Construction Drawings (PlansProfiles)_v1.pdf Markup Summary

8-29-2022

Cursory comments

MAINTAIN MINIMUM 18" VERTICAL AND 10' HORIZONTAL SEPARATION BETWEEN STORM SEWER AND POTABLE WATER OR WASTEWATER. A 12" VERTICAL CLEARANCE MUST BE MAINTAINED BETWEEN IRRIGATION LINES.

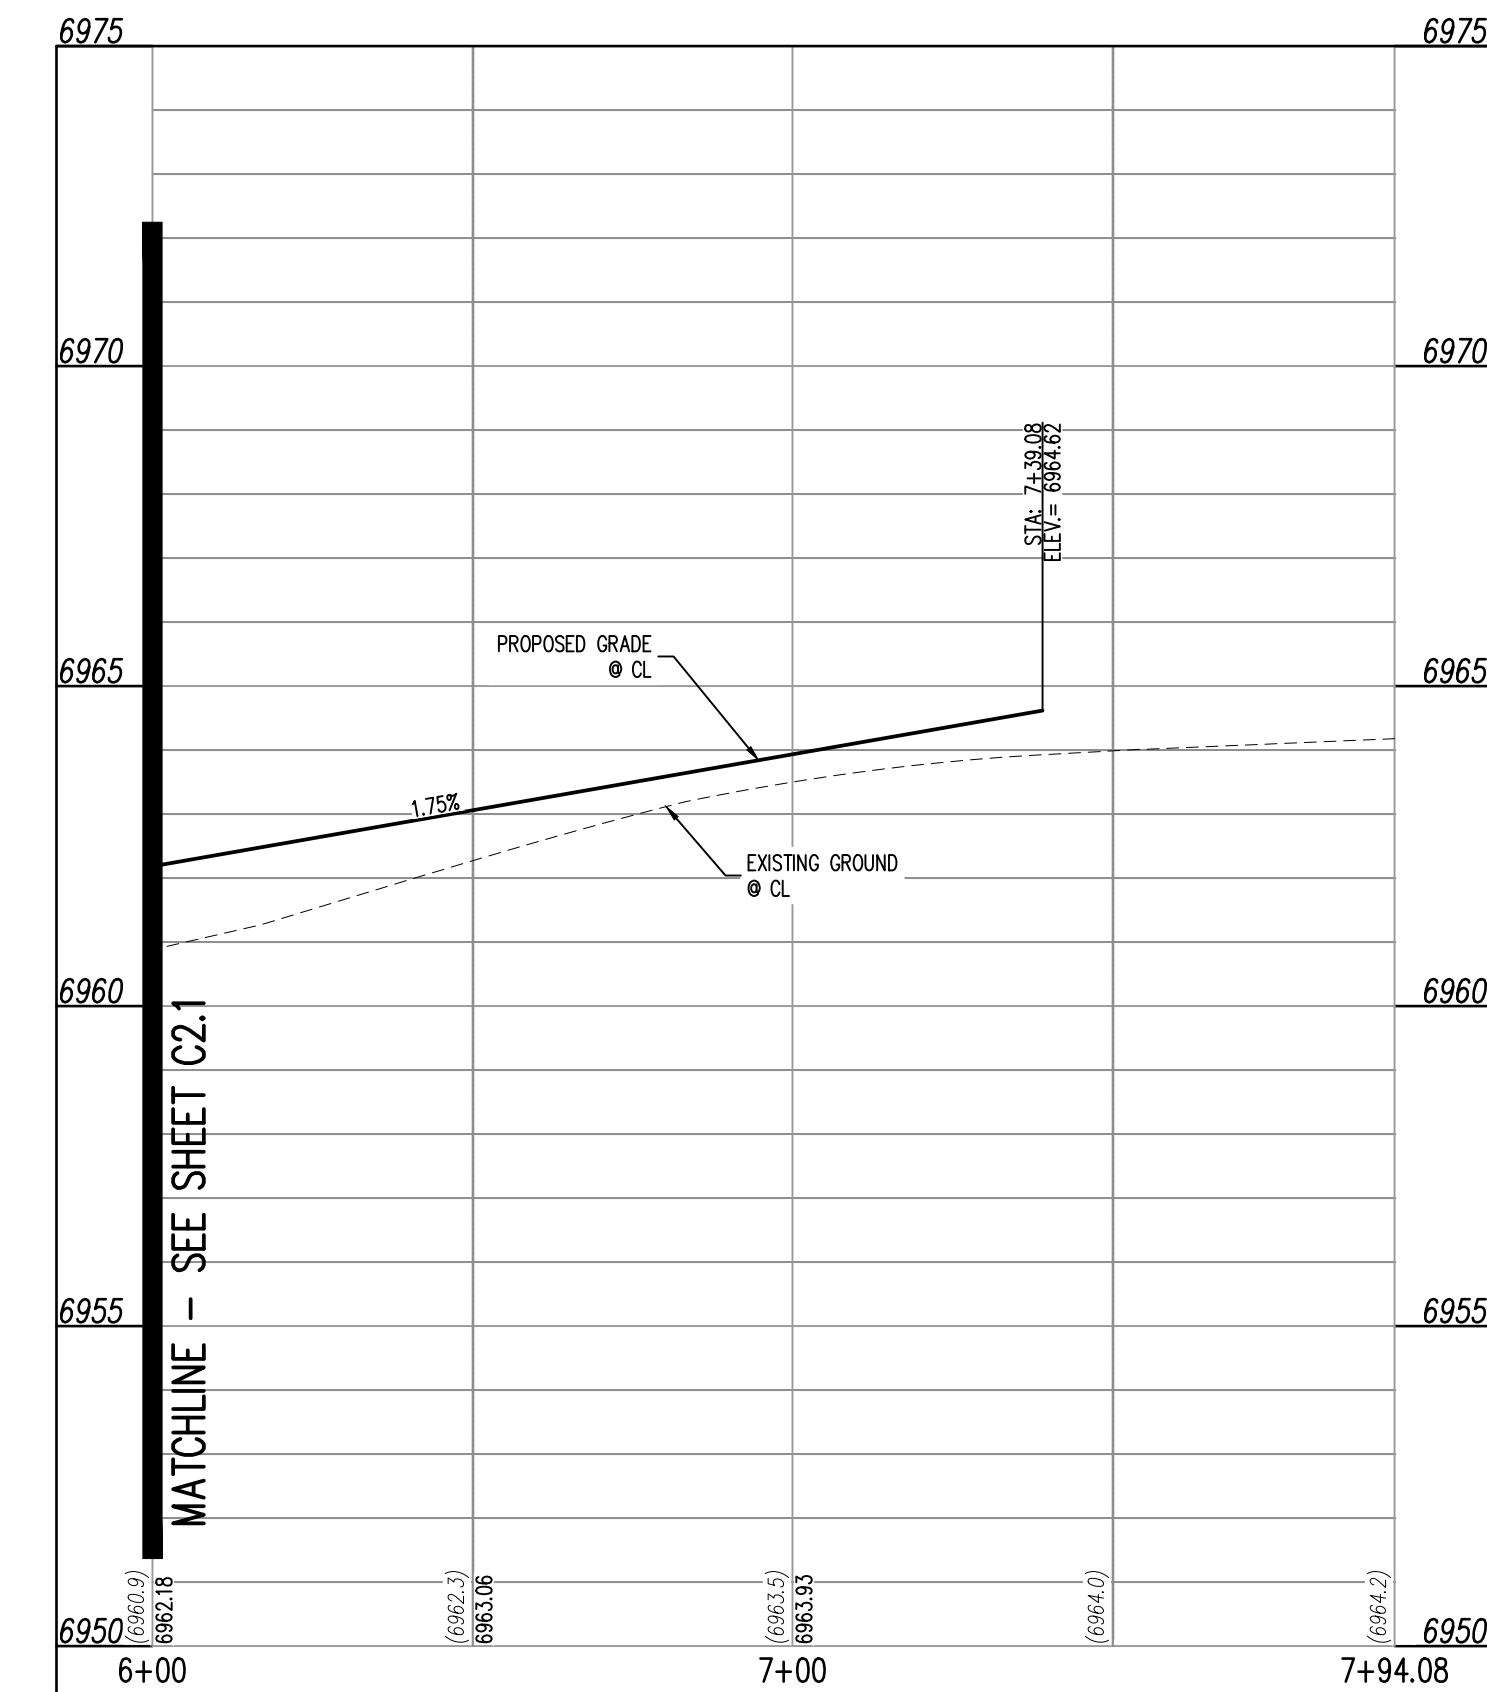
There appears to be a 3% grade break here - revise tangent to VC

Reduce grade break to <1% and space away from the vertical curve or remove and adjust the vertical curve

Subject: Callout
Page Label: [5] 5 LEMON GRASS RD IMPROVEMENT PLAN Provide vertical curves or reduce the grade break to $<1\%$
Author: dsdrice
Date: 8/19/2022 2:03:16 PM
Status:
Color: ■
Layer:
Space:

Subject: Callout
Page Label: [5] 5 LEMON GRASS RD IMPROVEMENT PLAN Does not meet minimum K values
Author: dsdrice
Date: 8/19/2022 2:05:14 PM
Status:
Color: ■
Layer:
Space:

Subject: Callout
Page Label: [5] 5 LEMON GRASS RD IMPROVEMENT PLAN Provide sight visibility triangles
Author: dsdrice
Date: 8/19/2022 2:46:29 PM
Status:
Color: ■
Layer:
Space:

Subject: Callout
Page Label: [5] 5 LEMON GRASS RD IMPROVEMENT PLAN Label as centerline-centerline intersections
Author: dsdrice
Date: 8/19/2022 2:48:41 PM
Status:
Color: ■
Layer:
Space:

ROAD IMPROVEMENT
 PLANS

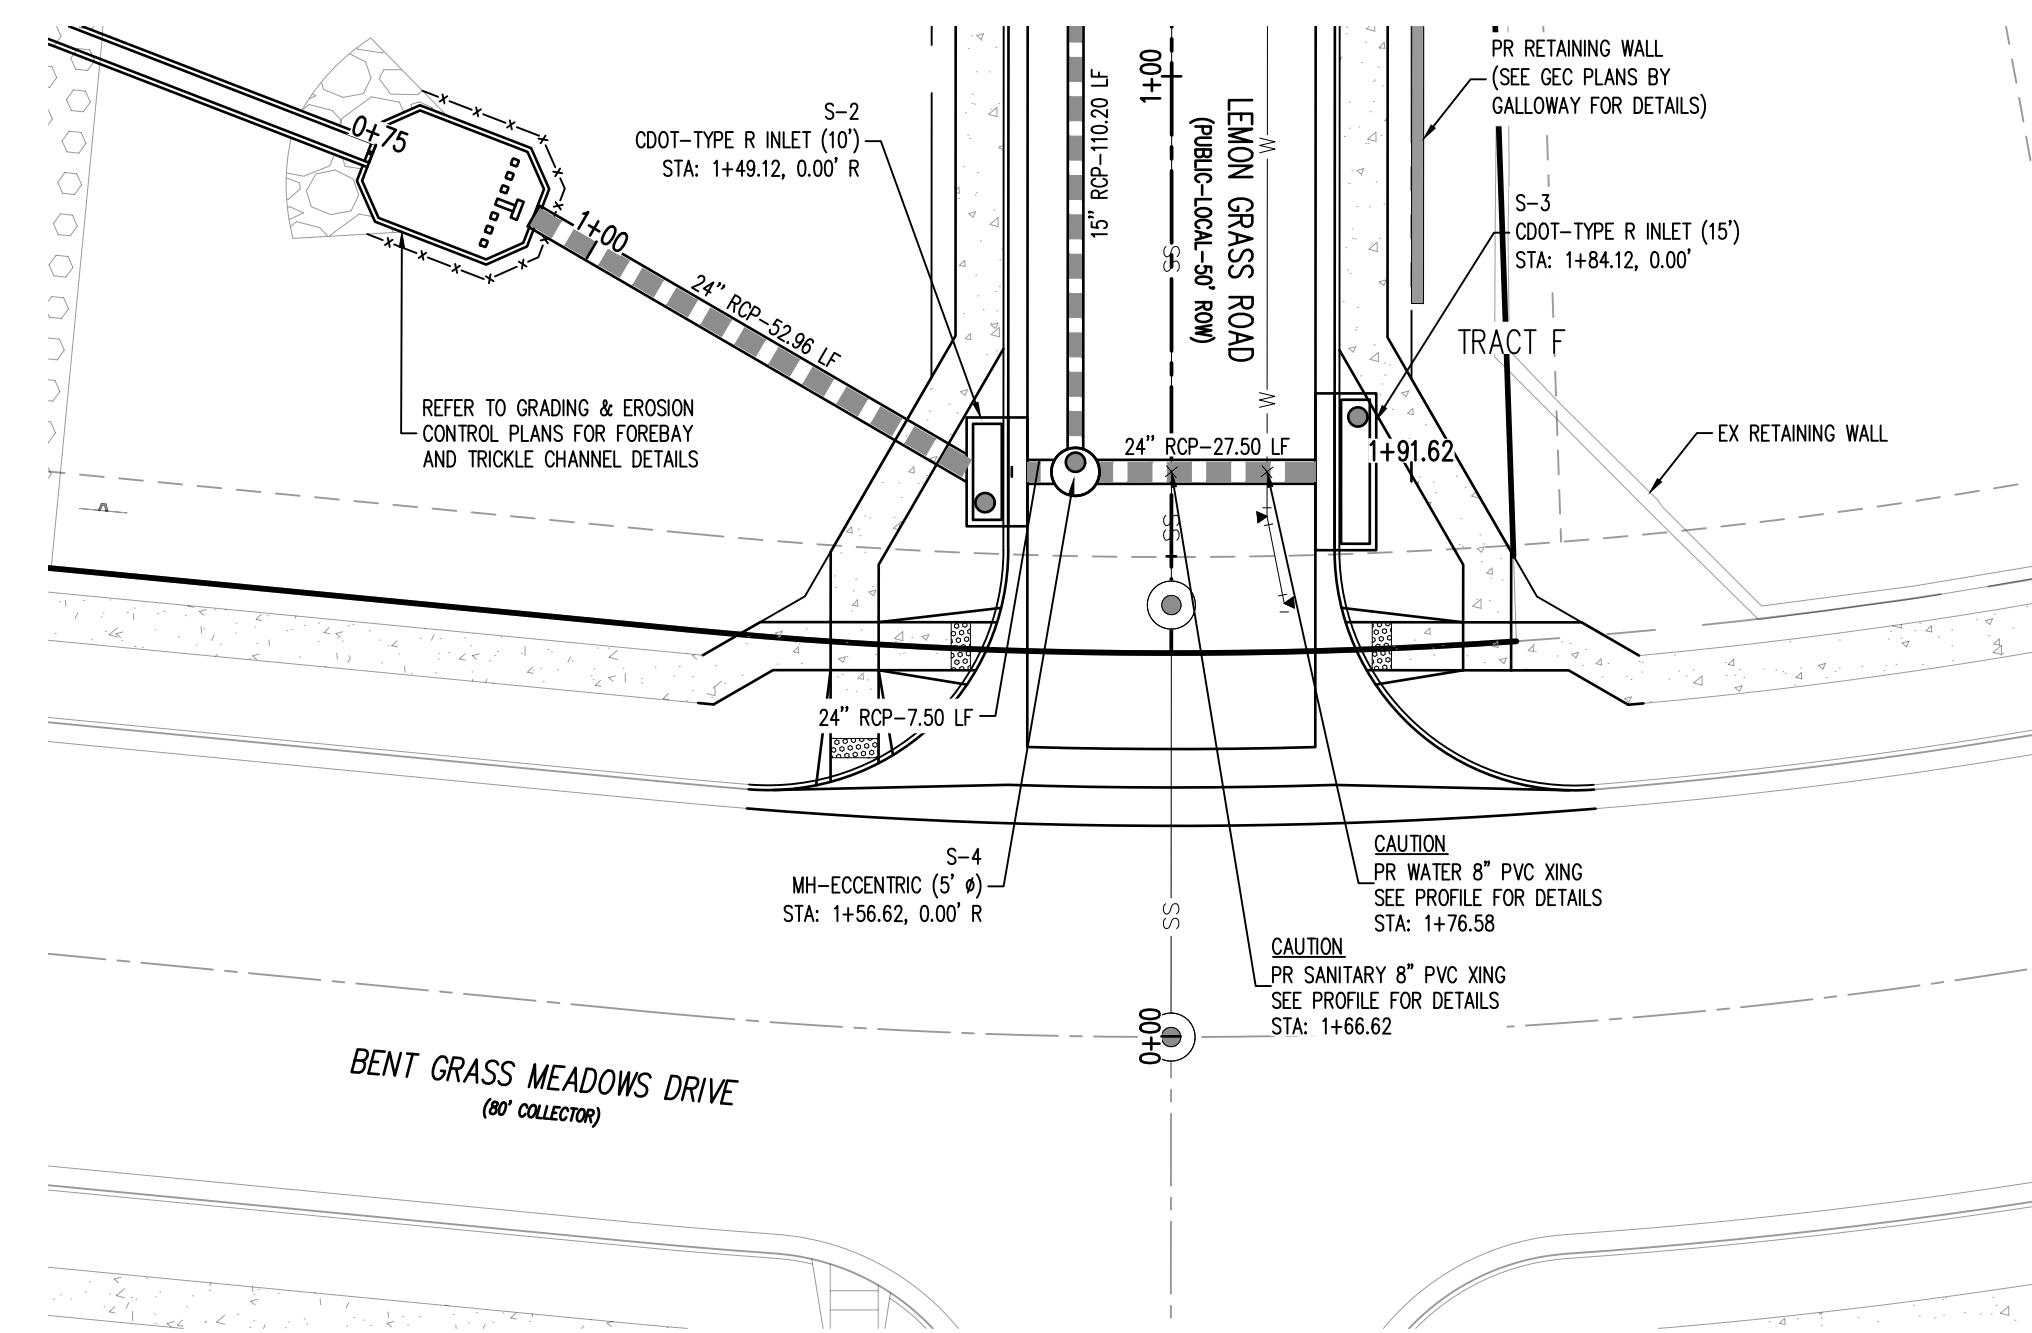
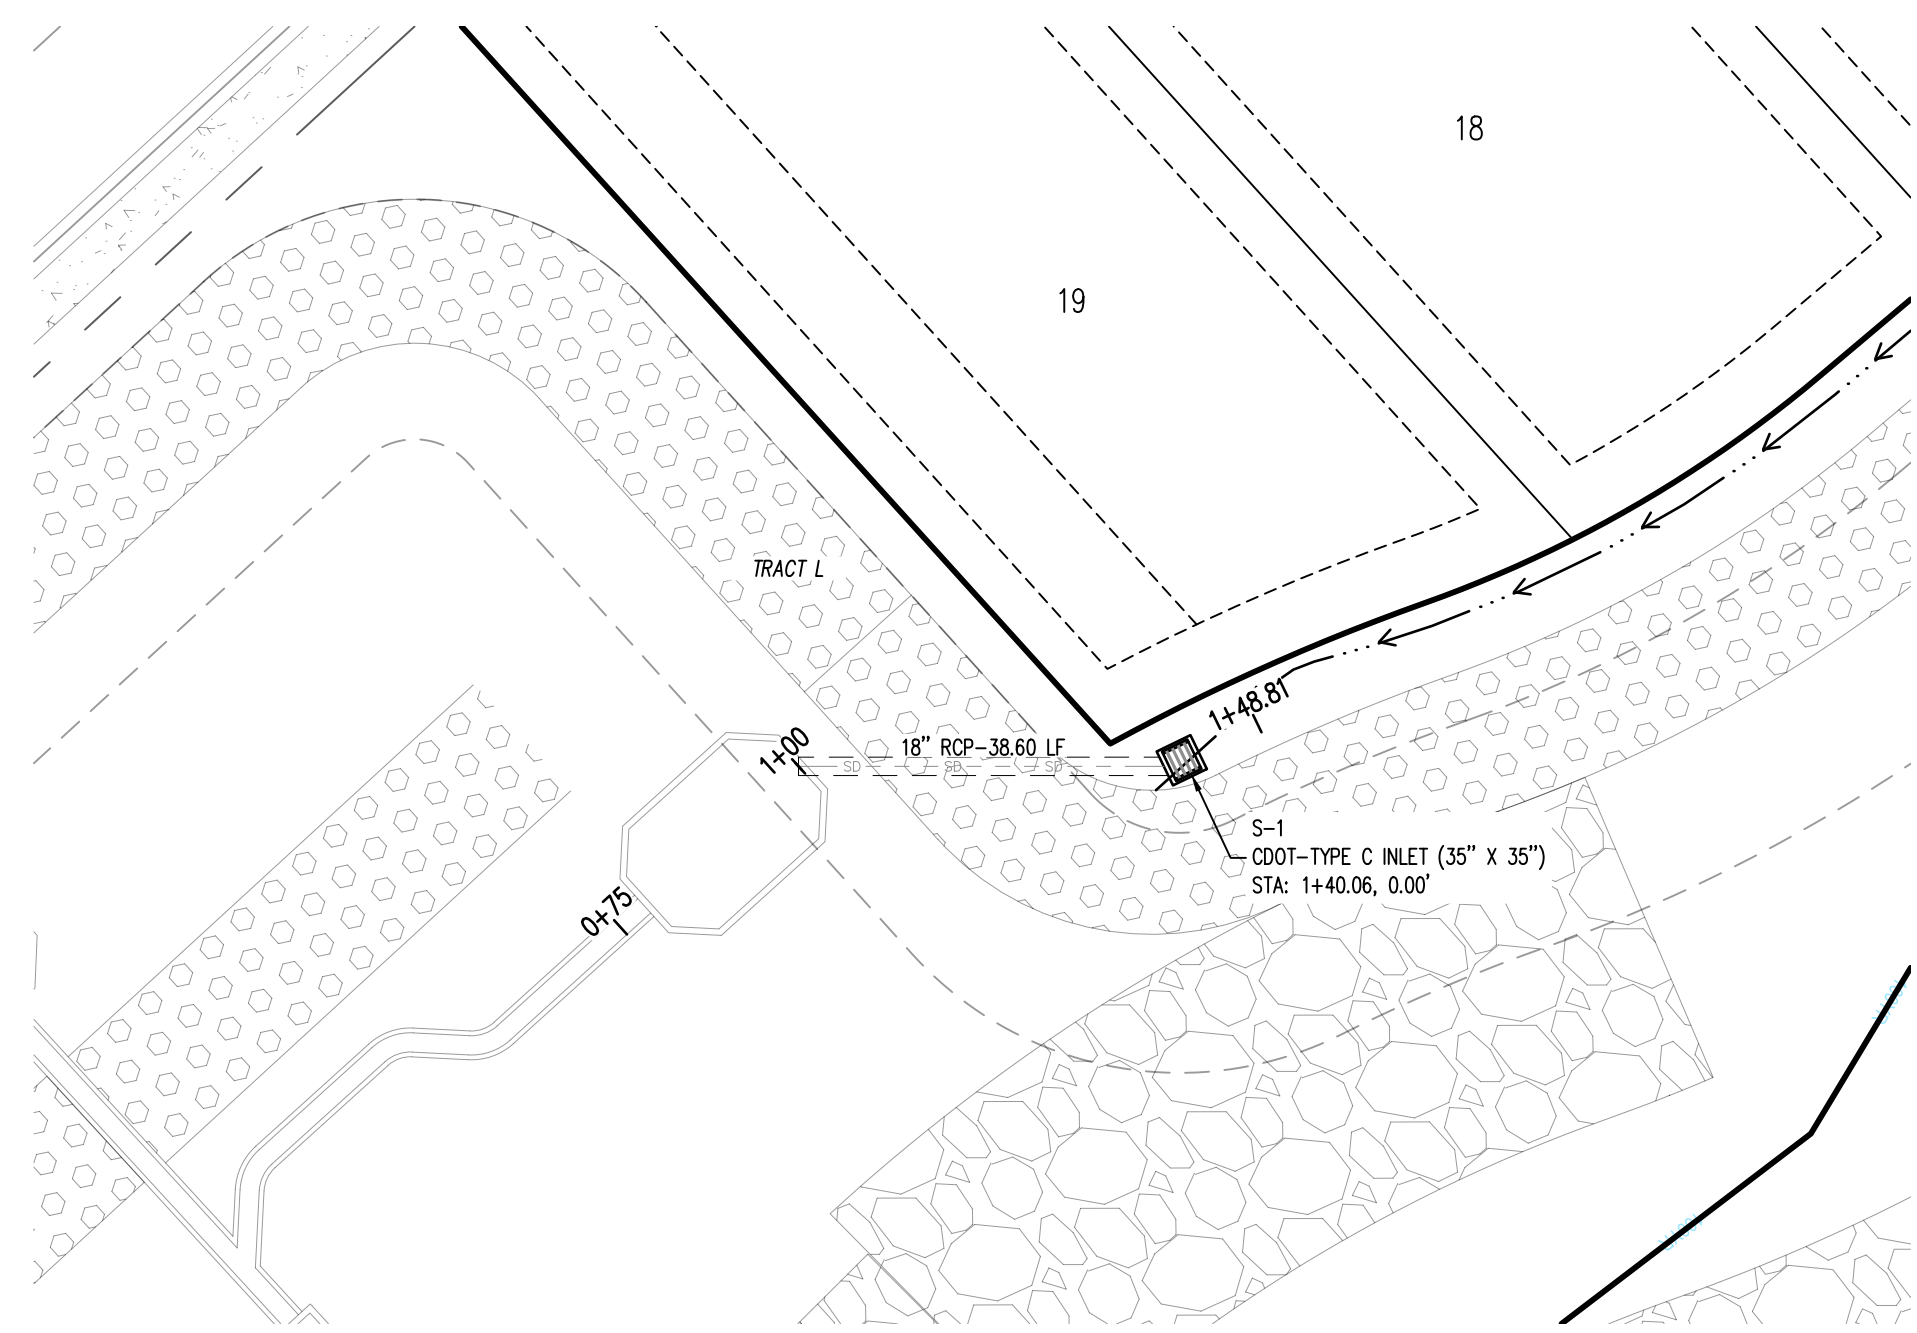
Subject: Callout
Page Label: [7] 7 ROAD IMPROVEMENT PLANS Call out crossspans and per SD_2-26
Author: dsdrice
Date: 8/19/2022 2:14:36 PM
Status:
Color: ■
Layer:
Space:

Subject: Callout
Page Label: [7] 7 ROAD IMPROVEMENT PLANS Show and label the existing 3% grade; revise design as appropriate
Author: dsdrice
Date: 8/19/2022 2:13:19 PM
Status:
Color: ■
Layer:
Space:

Subject: Callout
Page Label: [7] 7 ROAD IMPROVEMENT PLANS Show and label the existing 3% grade; revise design as appropriate
Author: dsdrice
Date: 8/19/2022 2:13:09 PM
Status:
Color: ■
Layer:
Space:
